DECISION DELEGATED TO HEAD OF PLANNING

Application No: H11-0708-25 **Applicant:** Mr R Tilbrook
Proposal: Erection of two storey and single storey rear extension and two storey side extension
Location: 87 Little London Long Sutton Spalding
Terminal Date: 14th November 2025

Proposed Block Plan
Scale 1:500

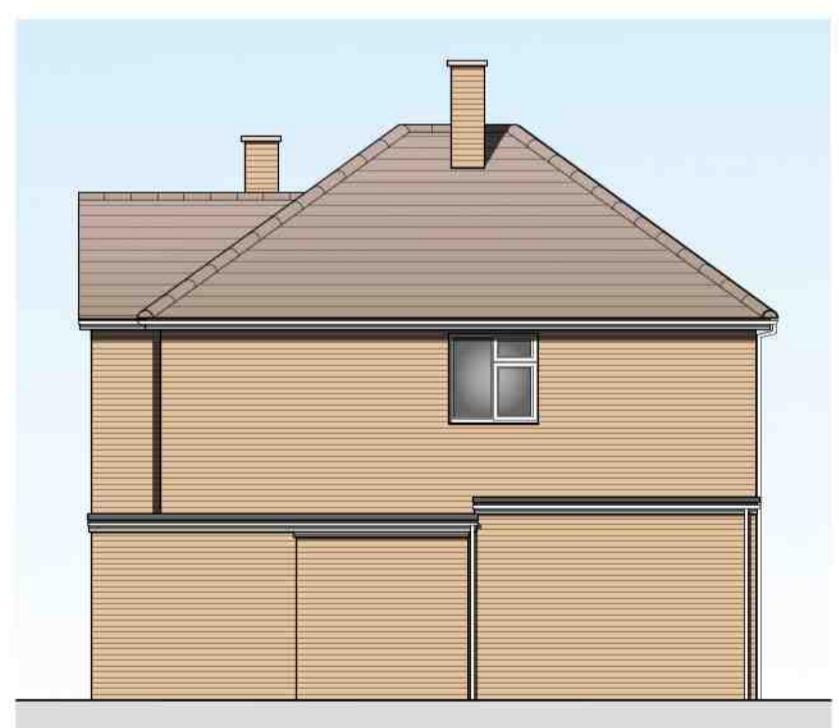
There would be an increase from three to four bedrooms meaning that at least three vehicle parking spaces must be provided on site to accord to Appendix 6. The proposed block plan clearly indicates

room for three vehicles to be stored safely off-street. LCC Highways have also raised no objections from a highway safety point of view and the development should not cause a severe impact on the highway.

Proposed Rear (W) Elevation  
Scale 1:100

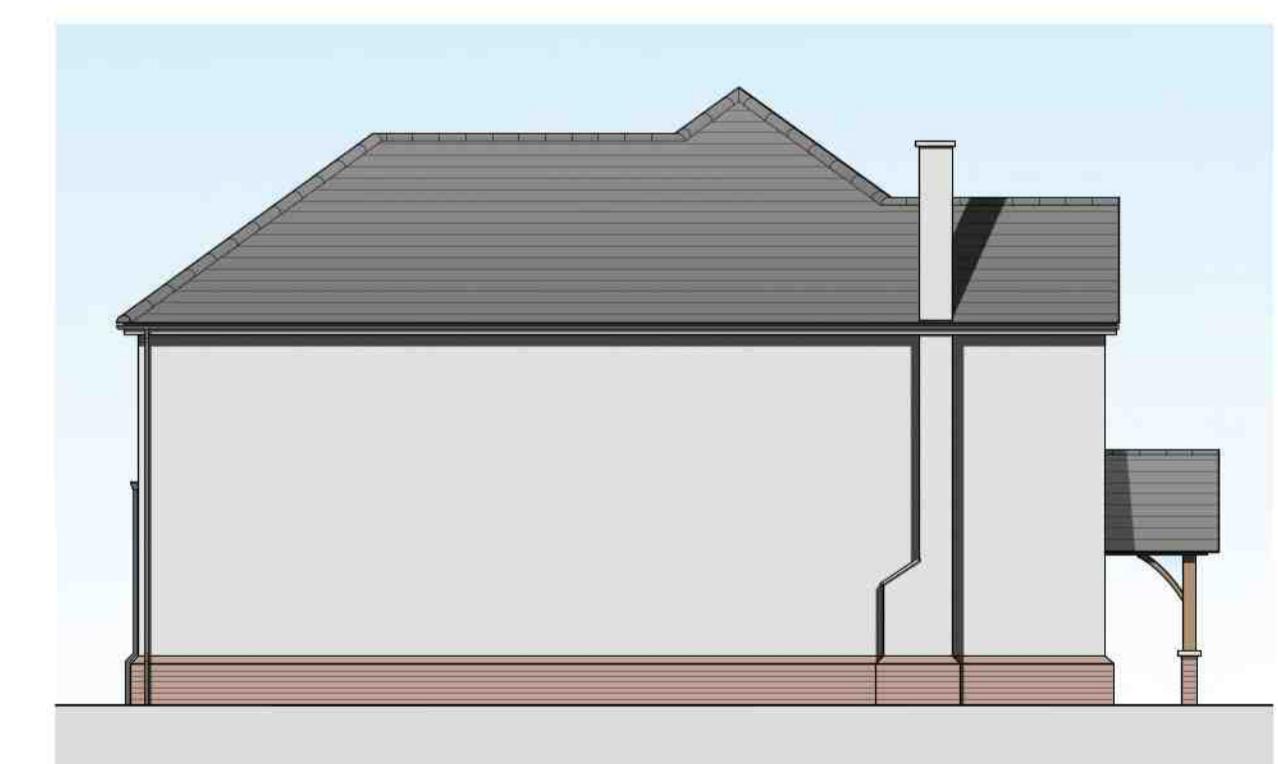
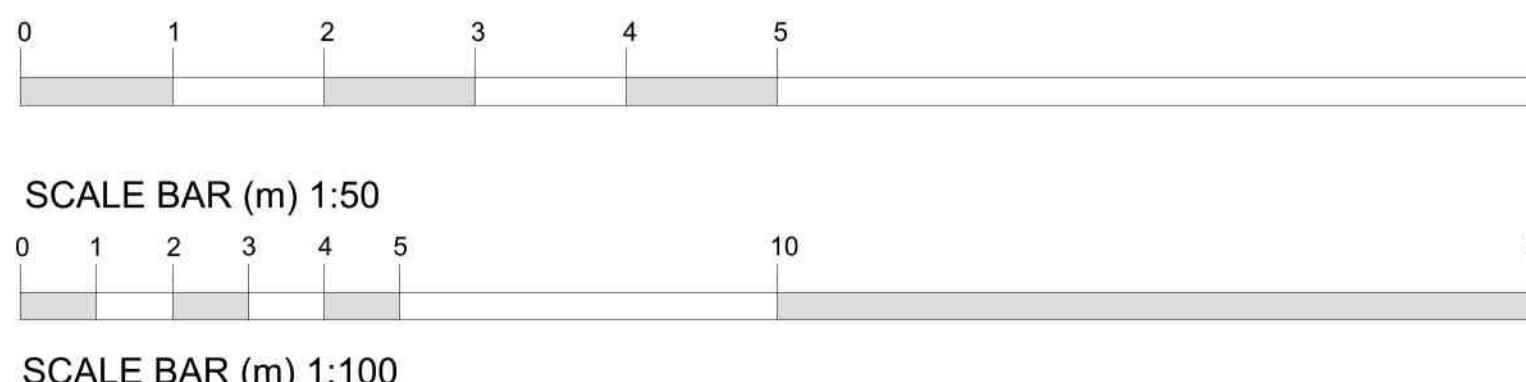
The proposed rear balcony may also be considered as an intrusion into neighbouring properties as with the large extension protruding at the rear of the property.

I am particularly concerned about the loss of privacy for adjacent houses, given the proposal for a Juliette balcony at the rear of the property, along with the possible loss of light. To this end, I would be grateful if you could treat my letter as an objection to this planning application.

Further to this, the proposed rear extension would comprise an eaves height that would be level to the main dwelling, sitting at 5000mm; whilst the ridge height is proposed as to be lesser in height than that of the host dwelling, at 7600mm; albeit, the height of the dwelling is also to be increased. This would result in the this extension, in respect of its scale and height in isolation, appearing subservient and subordinate in relation to the main host dwelling.

With regard to the two storey rear extension, there would be no unacceptable or significant impact to the east and west due to the distance to the western neighbour and there being the host dwelling to the east to which the extension adjoins. Any overshadowing that would occur would affect the northern neighbour mostly. The LPA do not consider the potential overshadowing impacts to be material or significant enough to warrant a refusal. The height of this two storey extension sits at approximately 7500mm, which is considered to be acceptable in this instance. It should be noted that the height of the dwelling would also increase following the completion of these works to around 8100mm. However, this would be somewhat a modest scale and would not increase to a harmful extent; not giving rise to an unacceptable impact. It should also be noted that this enlargement was previously permitted and remains part of an extant permission on site, which can be developed irrespective of the outcome of this application.

In respect of the layout, there would be two new windows along the rear elevation. These would serve an en-suite and master bedroom. A condition would be attached to the decision notice to ensure the en-suite window is obscure glazed to minimise any overlooking potential through this. Whilst the window for the master bedroom could provide some outlook, this would not result in a material loss of privacy that would warrant refusal in this case. The previous proposal approved windows for two bedrooms on the rear elevation. Although the new bedroom window would extend further back, this would not result in any new additional concerns or outlook in comparison to what could be carried out with the extant permission. As such, no material overlooking or loss of privacy should occur following construction.

The Local Planning Authority received a larger scheme in respect of this rear extension through the initial plans submitted as part of this application. Further to discussions, it was requested that the rear extension was reduced, as to increase its separation, at a two storey scale, from this northern neighbour. As such, the amended plans as determined, comprise a reduced scheme, which allows for a single storey projection within its closest proximity along this rear elevation.

Public representations during the consultation period have raised concerns regarding overshadowing which have been noted; however, this scheme, as amended, is not considered to cause any material loss of light for a significant period of time throughout the course of the day, which would lead to an unacceptable or significant adverse impact to the amenities of the neighbouring occupiers. As such, this is considered to be an acceptable proposal in this regard.
